Project# 1001370

15DRB-70436 EPC APPROVED SDP FOR SUBDIVISION - JUAN TABO HILLS UNIT 2

PROJECT NO. 1001370 / 15EPC - 40025

**Re: Site Development Plan for Subdivision for Tract 1-A-1 of Juan Tabo Hills, Unit 2
CPN # 1001370**

**TRACT 1-A-1, JUAN TABO HILLS UNIT 2
 SITE DEVELOPMENT PLAN FOR SUBDIVISION**

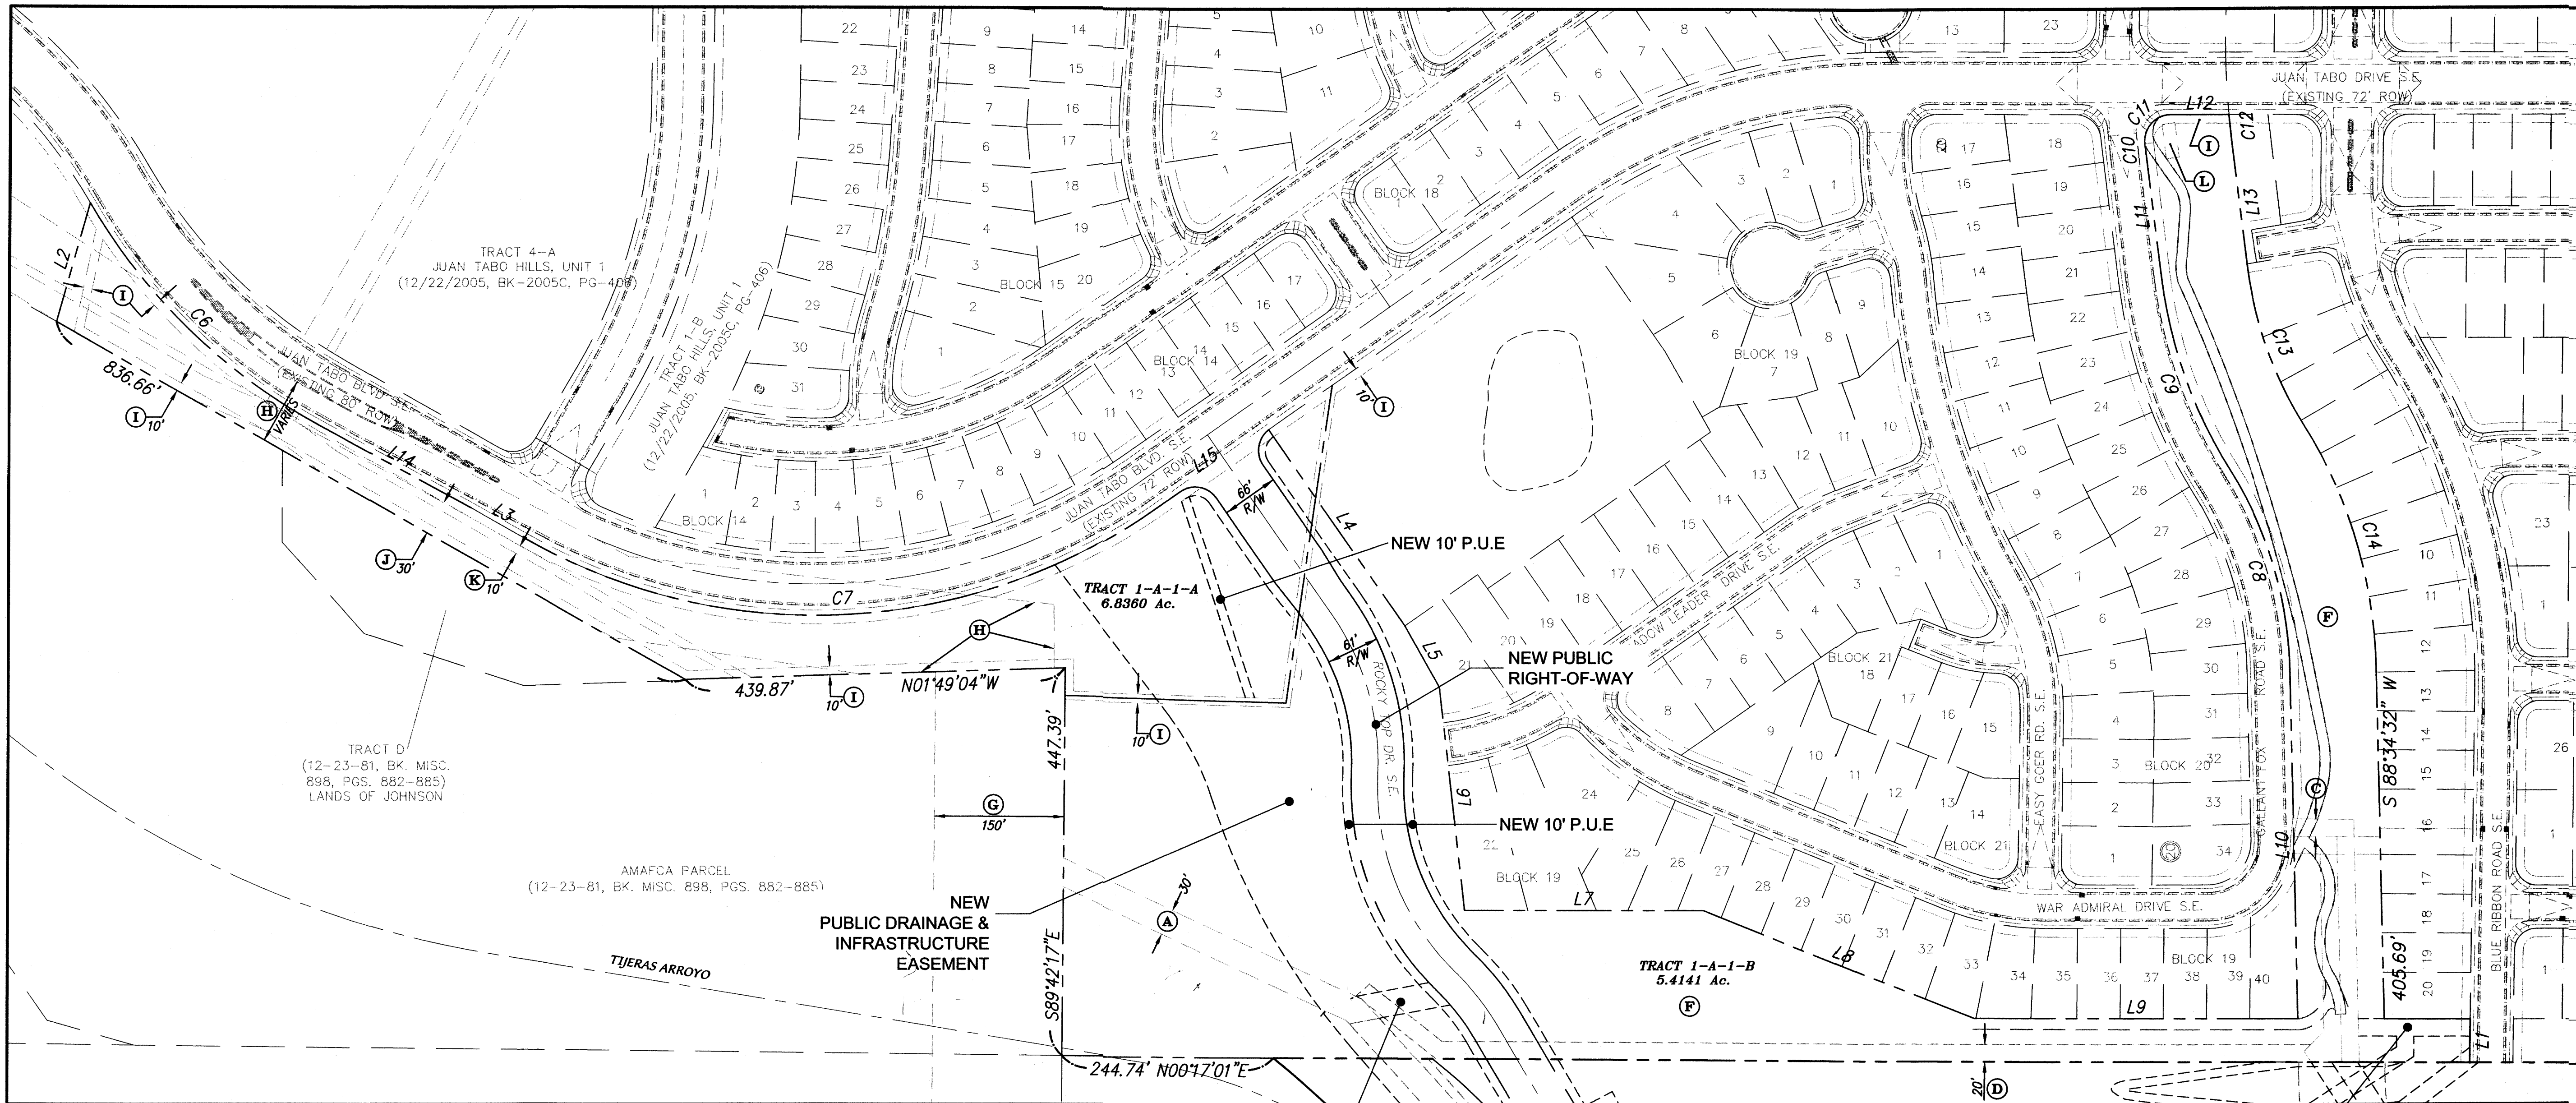
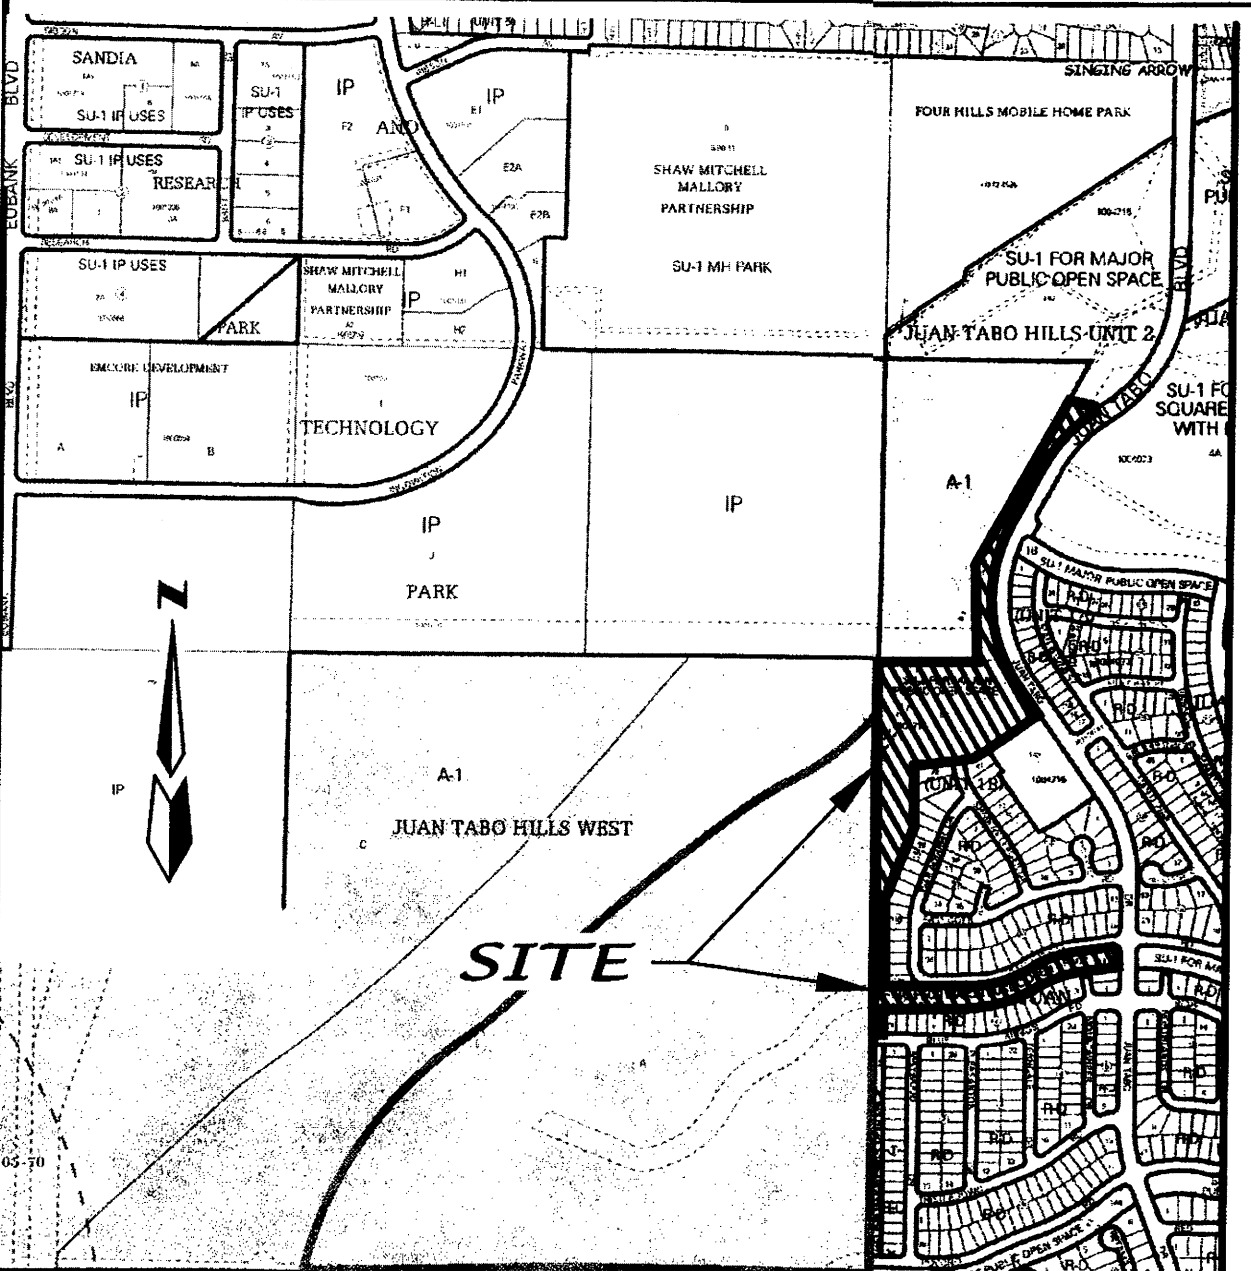
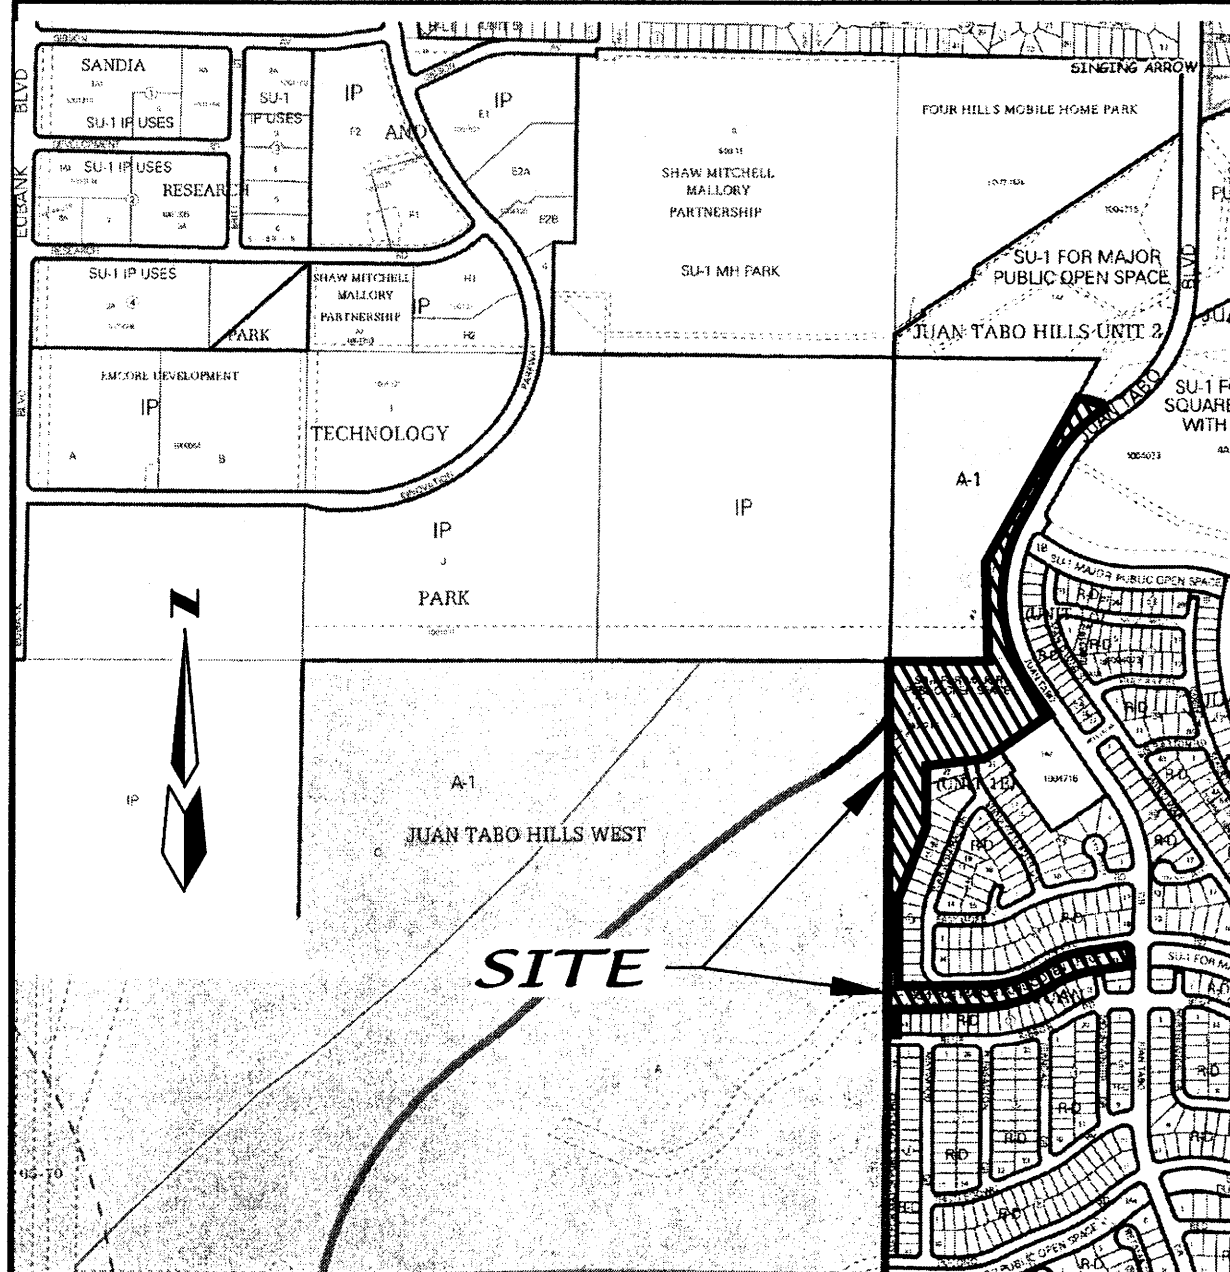
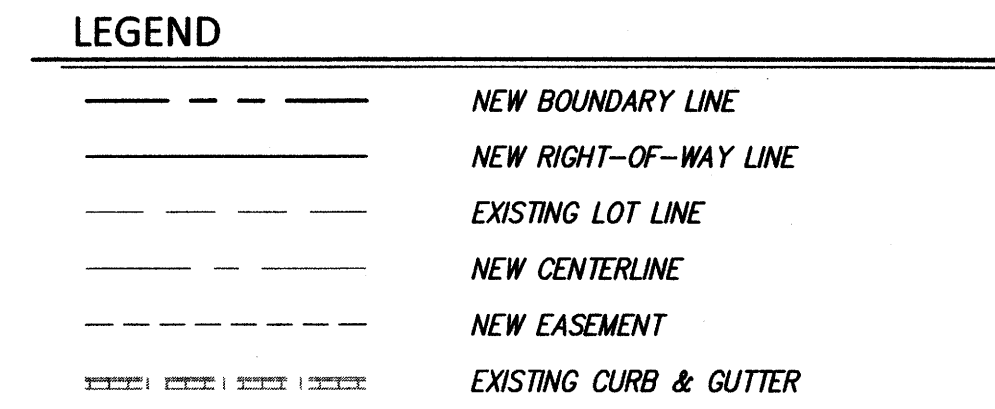
1. Please provide an overall site plan showing the proposed road as well as the roadway section. The typical sections were/will be provided with the Preliminary Plat (see e-mail sent 11/12/2015)
2. For final plat, any access easements need to be shown with all beneficiaries and maintenance responsibilities listed. Easements have been shown and note 5 added on site plan, and will be shown on both the preliminary and final plats.
3. All improvements located in the Right of Way must be included on a work order. Note 2 on the site plan addressed further approvals.

1. The apparent limits of the "Public Drainage & Infrastructure" easement do not coincide with the drainage infrastructure on the site. Easement line locations have been revised.

2. "Public Drainage & Infrastructure" needs to be separated into a Slope Easement for the retaining wall system and a Drainage Easement for the drainage structures within Tract 1-A-1 (pond, outlet & inlet pipes within tract). A private Slope easement has been added for maintenance of the retaining wall. Easement 'F' is an existing Blanket Drainage Easement over the entire site that already included the pond, outlet & inlet pipes. However an additional easement has been added per your request

3. The plan needs to show the AMAFCA easement which clips the tract. A new AMAFCA Drainage easement has been added for the Bank Protection and thalweg of the Tijeras Arroyo.

4. The footprint of the drainage features needs to be approximately shown on the site plan. The footprint of the drainage features has been added back on the site plan even though the EPC requested that they be removed.

5. New easements need to include language regarding the beneficiaries and maintenance responsibilities. Beneficiaries and maintenance responsibilities have been added to the new easement notes..

6. It is Hydrology's understanding that the pond must be maintained by the private development (HOA or other agent). Neither the developer nor the HOA of that previously constructed

1. Does the proposed 20' waterline easement include the stub which terminates at the western property line? Is the intent only to connect the two existing 8" waterlines along both Blue Ribbon Rd. and arroyo, or is it for future extension into Juan Tabo Hills Estates to the west as well? The conceptual utility plan (emailed 9/29/15) did not include these connections. Please see new e-mail 11/02/2015. It shows looping of the two existing dead end water lines in Blue Ribbon and in the "arroyo" and a connection to Juan Tabo Hills Estates.

2. Include the existing public water and sanitary sewer easements along the arroyo, just south of Gallant Fox Rd. Labels have been added to the existing easements.

3. Easement D (existing 20' sanitary sewer easement) has an existing 8" sanitary sewer line located within it. How will the easement vacation be addressed as the sanitary sewer line is to be removed and disposed? The Vacation request is pending approval by the DRB in conjunction with the Preliminary Plat. The portion of the easement being vacated on that Plat has been hatched on the site plan, the hatch has been added to the site plan legend, and note 5 has been added to the site plan stating that the final location of those easements will be determined on the preliminary and final plats.

4. What is the purpose of the new 30' sanitary sewer easement on the north side of Rocky Top Dr.? It is for relocation of the SAS trunk line. The easement location has been adjusted on the site plan and now includes SAS to be maintained by ABCWUA and Access to be maintained by AMAFCA.

5. As the existing 8" sanitary sewer mentioned in #3 above is to be removed and disposed, what is. The question got cut off. Please note that the new easements for the relocated 8" SAS are west of Tract 1-A-1 and show up on the plat of the adjacent parcel but not on this site plan. Please see Conceptual Utility Plan e-mailed on 11/02/2015 and Preliminary Plat e-mailed on 11/12/2015.
